SUPPORTING STATEMENT

PROPOSED CHANGE OF USE FROM C4 HMO (up to 6 residents), TO SUIS GENERIS, LARGE HMO (7 or more residents) TOGETHER WITH ASSOCIATED INTERNAL ALTERATIONS

**34-36 WESTLODE STREET
SPALDING
LINCOLNSHIRE
PE11 2AF**

Drawing Title:
Floor plans as proposed

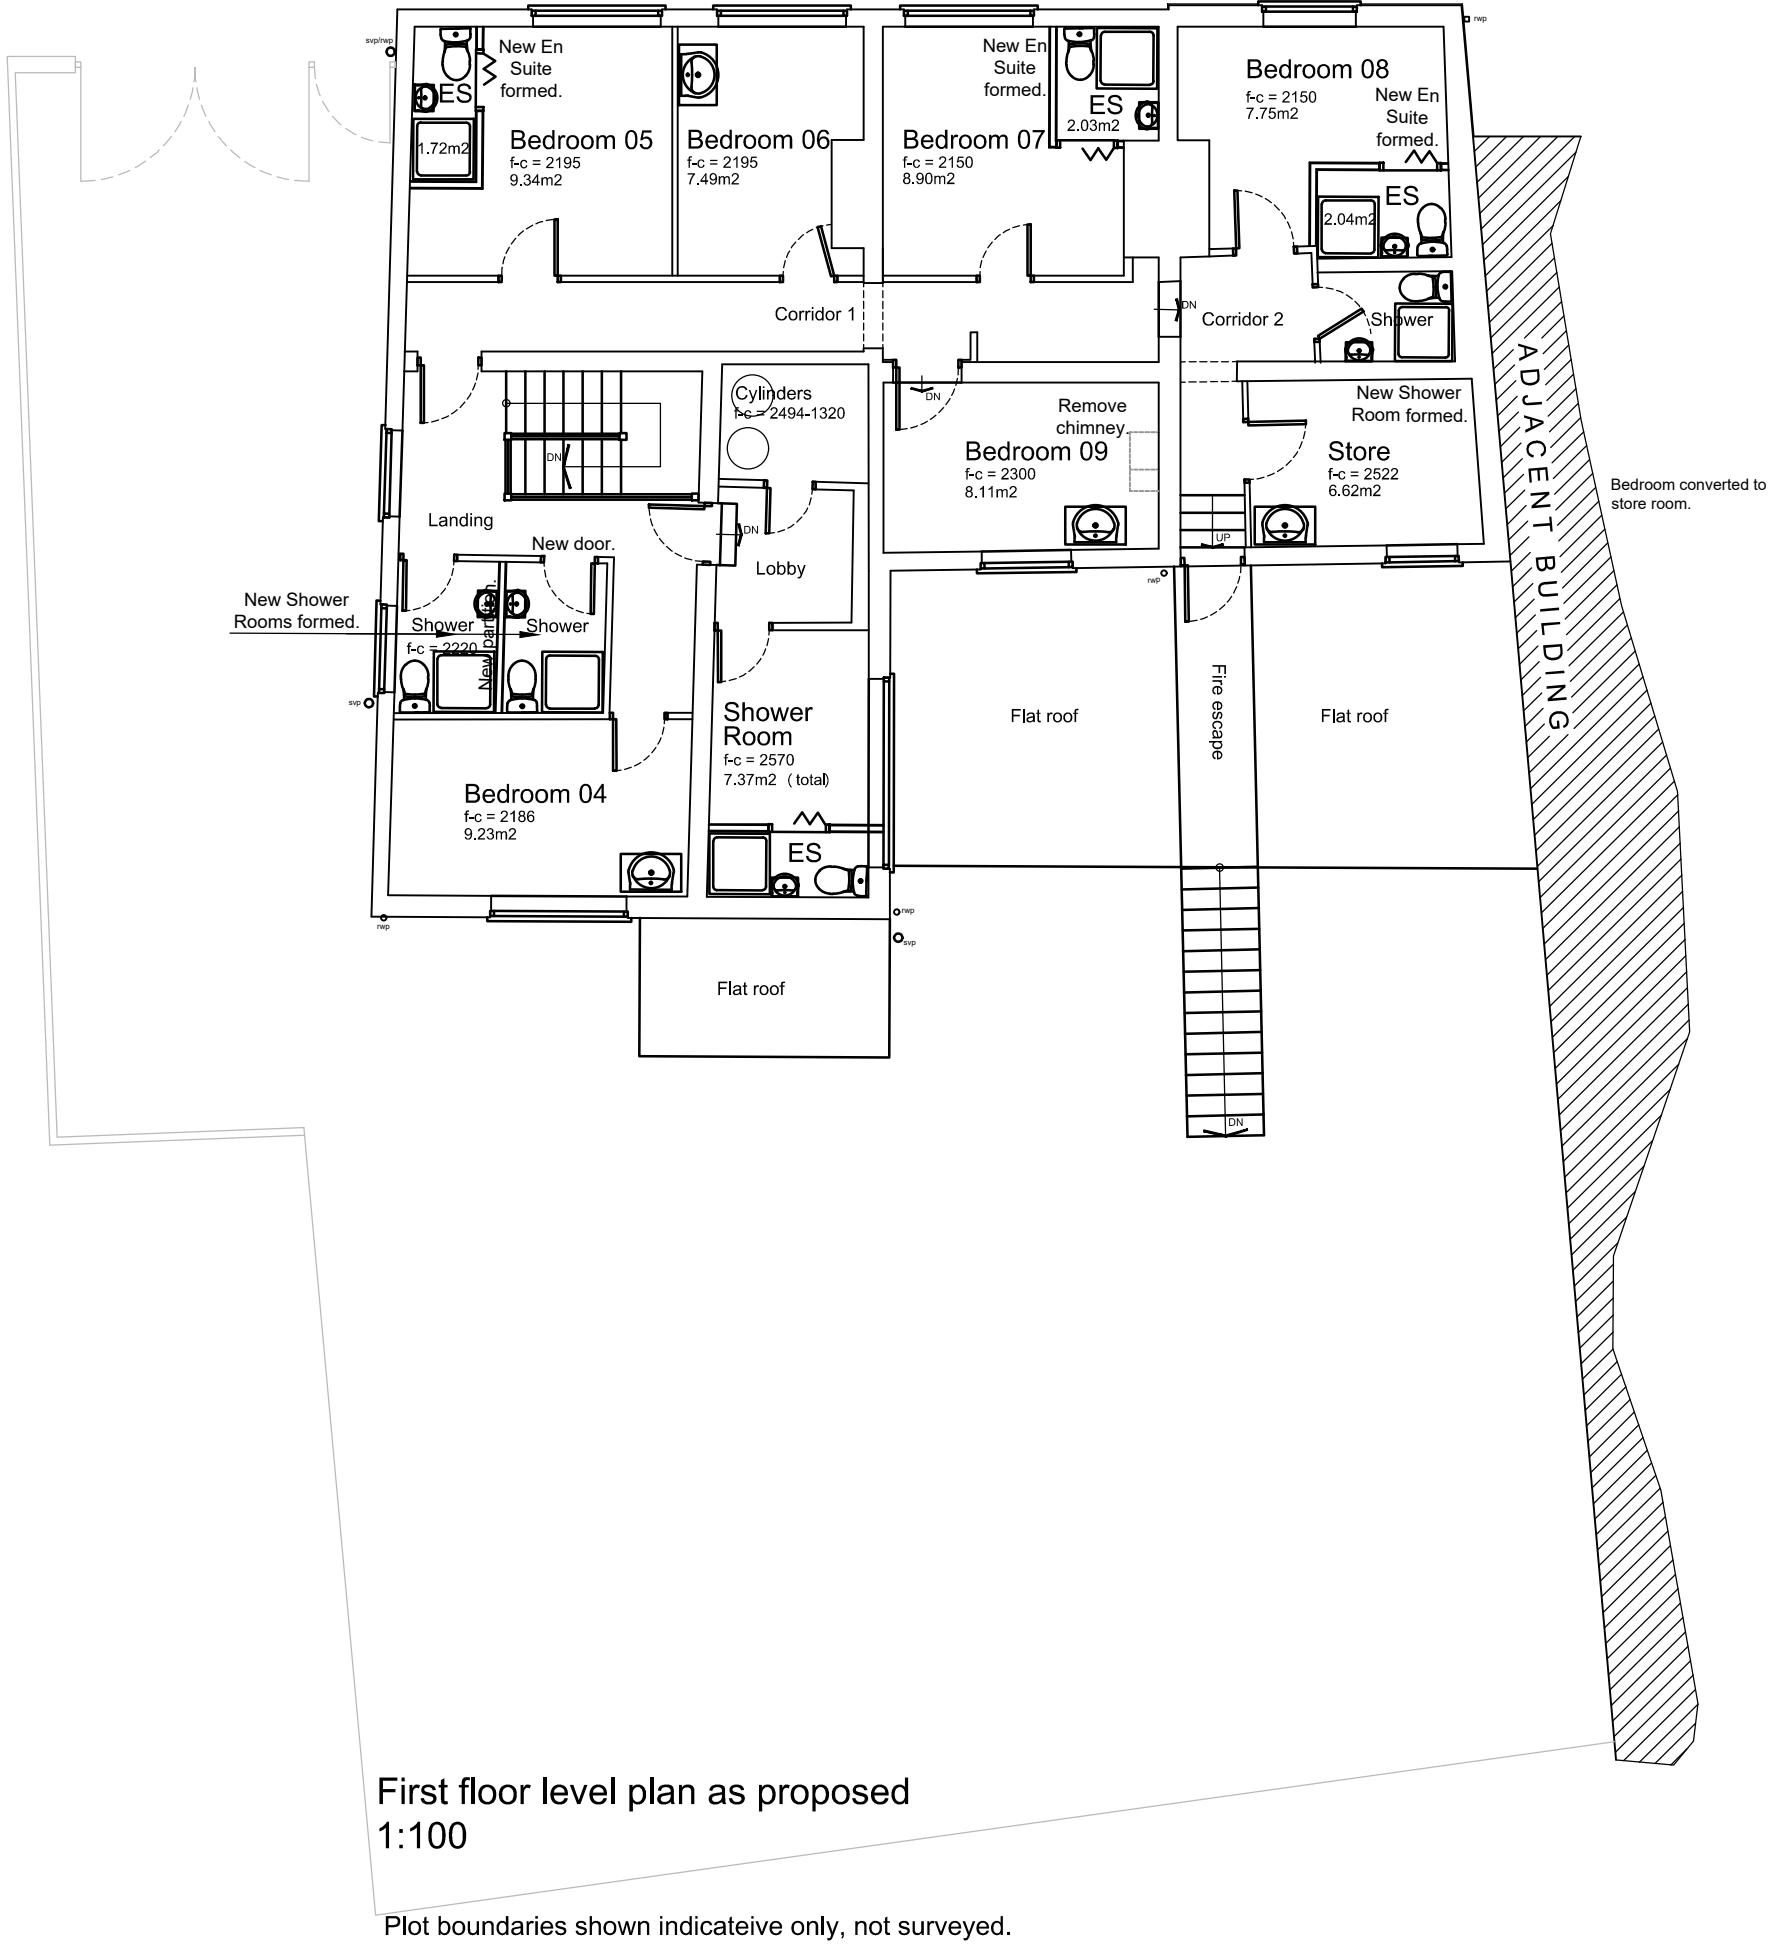
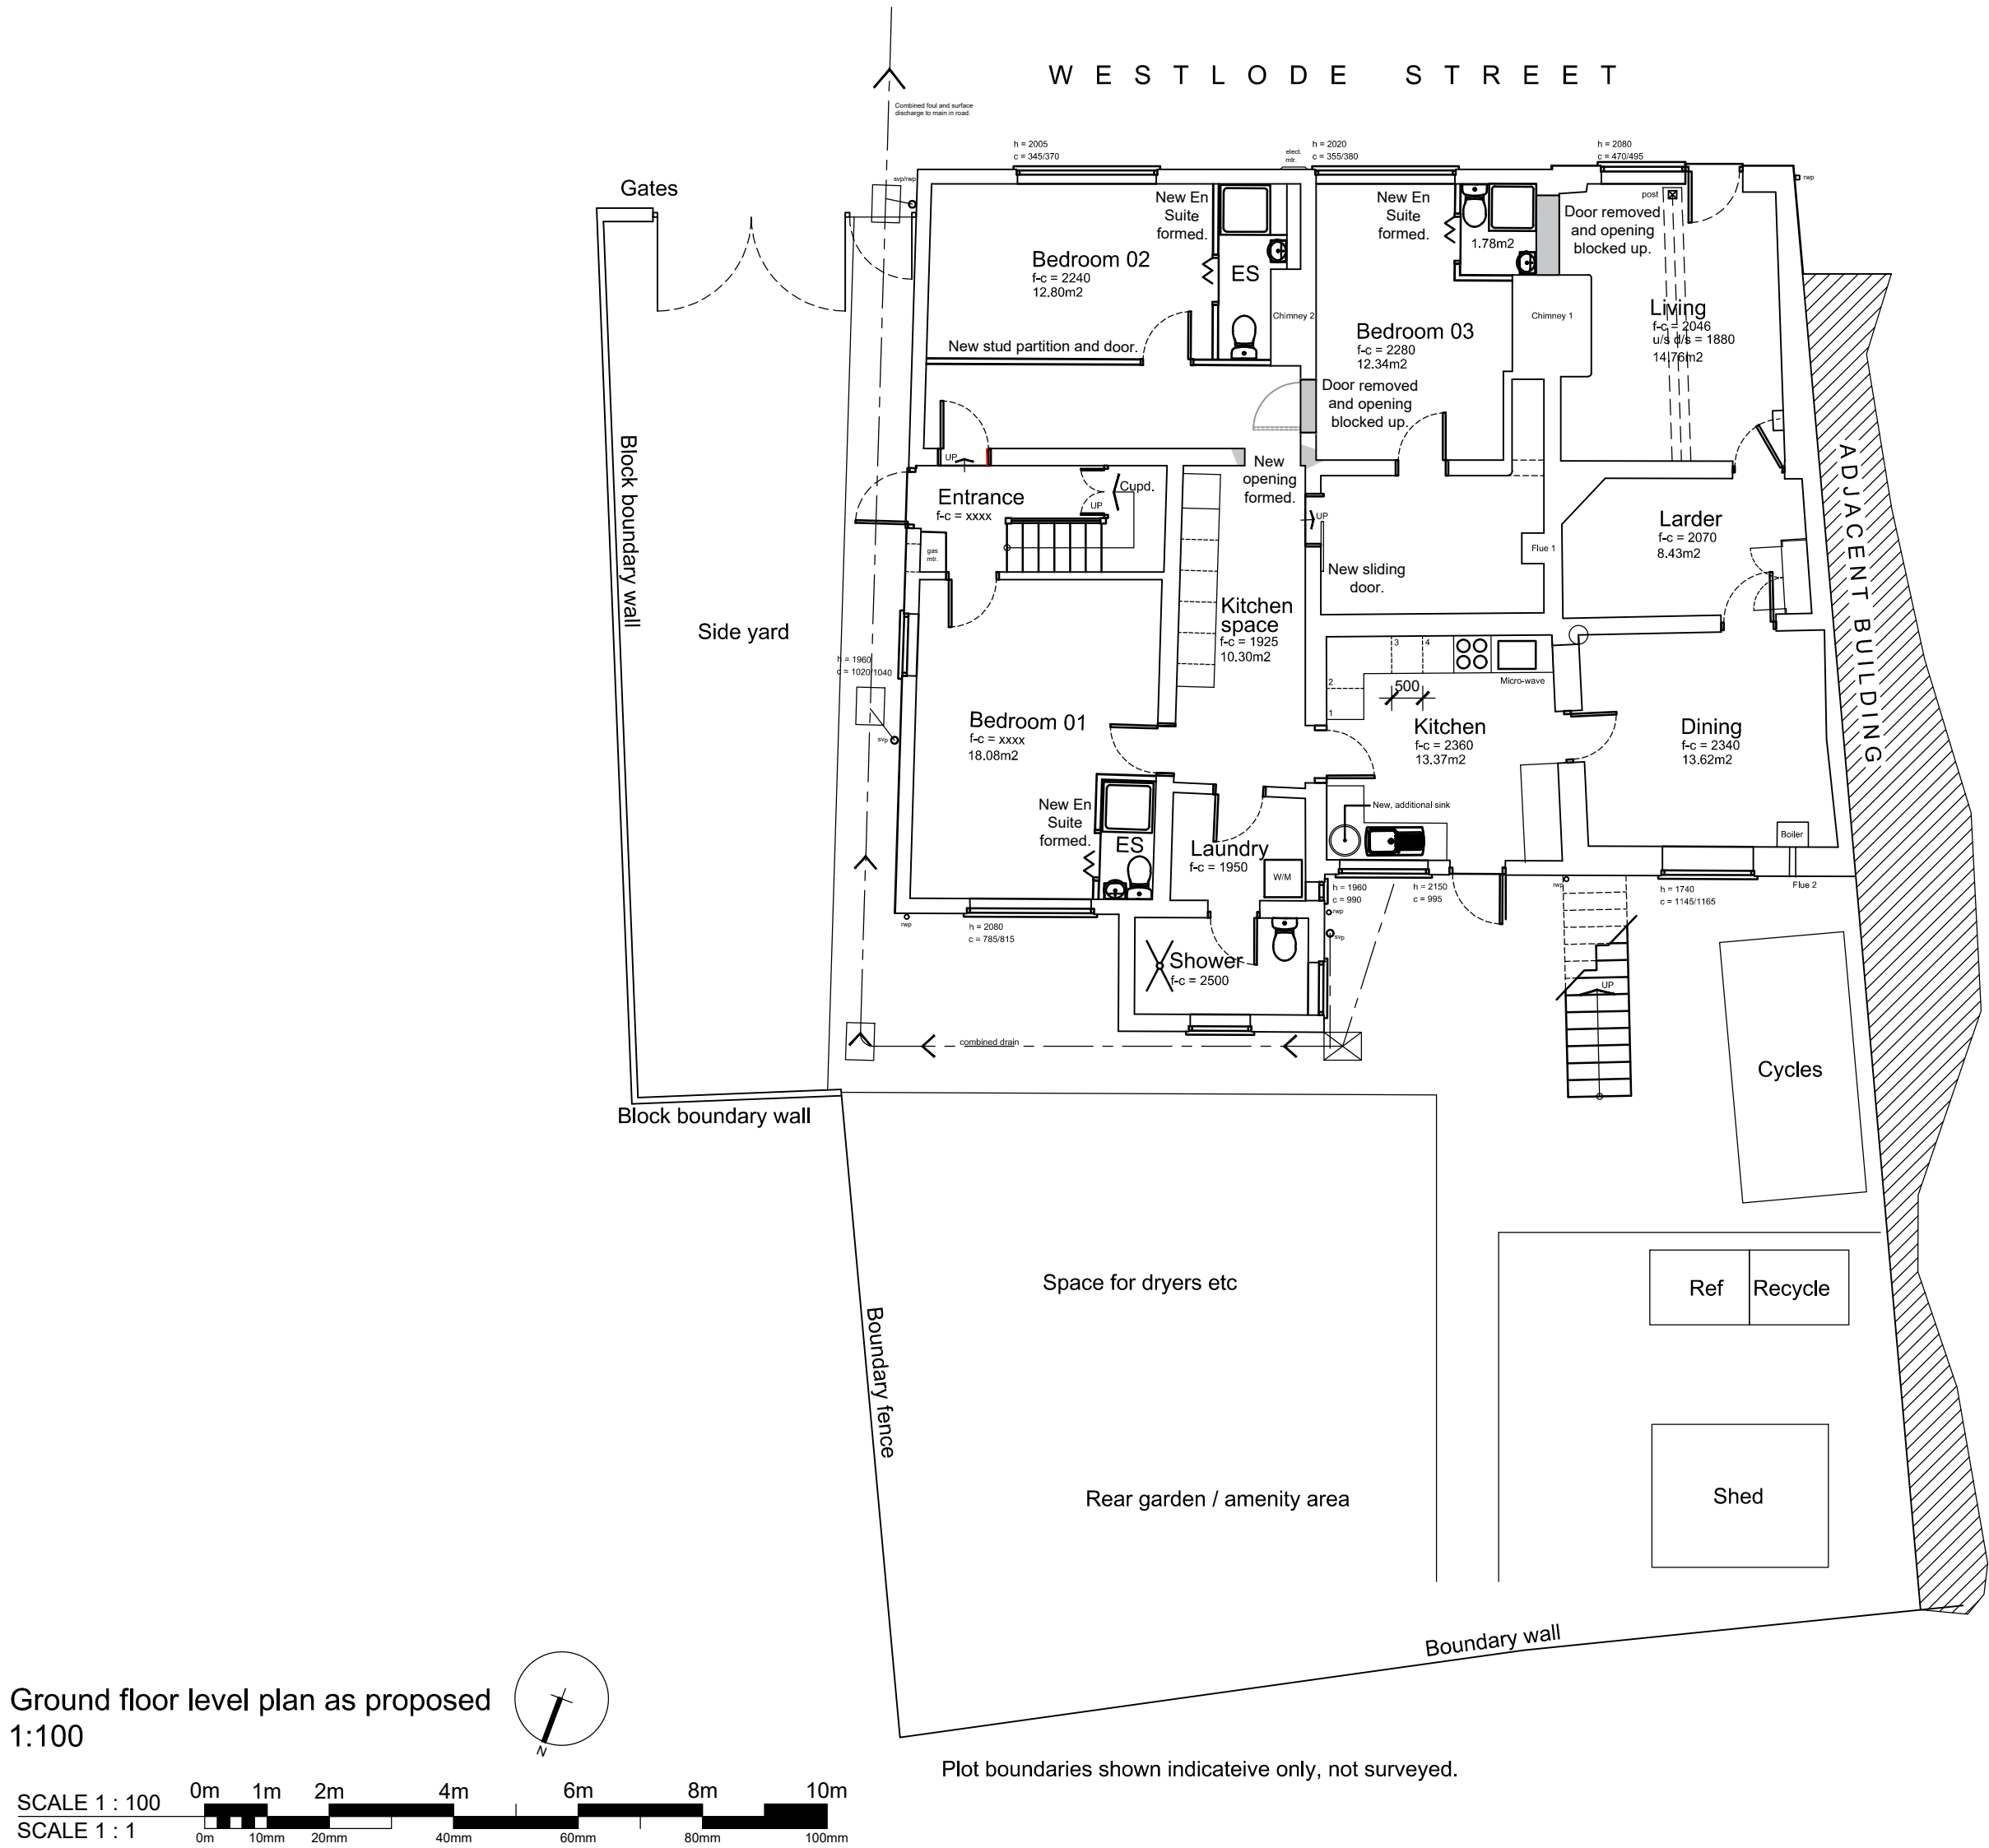
A previous application was submitted in March 2024. That application sought change of use but the total number of bedrooms proposed at the time was 12 (H16-0271-24). That application was refused for the following reasons:

1. Property considered to be of inadequate size to accommodate 12 persons.
2. Three of the proposed bedrooms were below acceptable standards in terms of room area.
3. Insufficient communal amenity space was provided inside the building.

4. Former proposed bedroom 05 has been changed to a communal shower room.
5. Former bedroom 12 has been changed to a store cupboard.
6. Former bedroom 04 has been changed to a second communal living room.
7. Bedrooms have been renumbered accordingly, now being 9 in total.

The total number of bedrooms has now been reduced from 12 to 9. The amount of internal communal amenity space has been increased by the provision of a further living room. Given these changes it is considered that the reduction in resident numbers from 12 to 9, together with the increase in communal amenity space now addresses the previous reasons for refusal. Hence this new application is submitted. A biodiversity statement is now also submitted in support of the application.
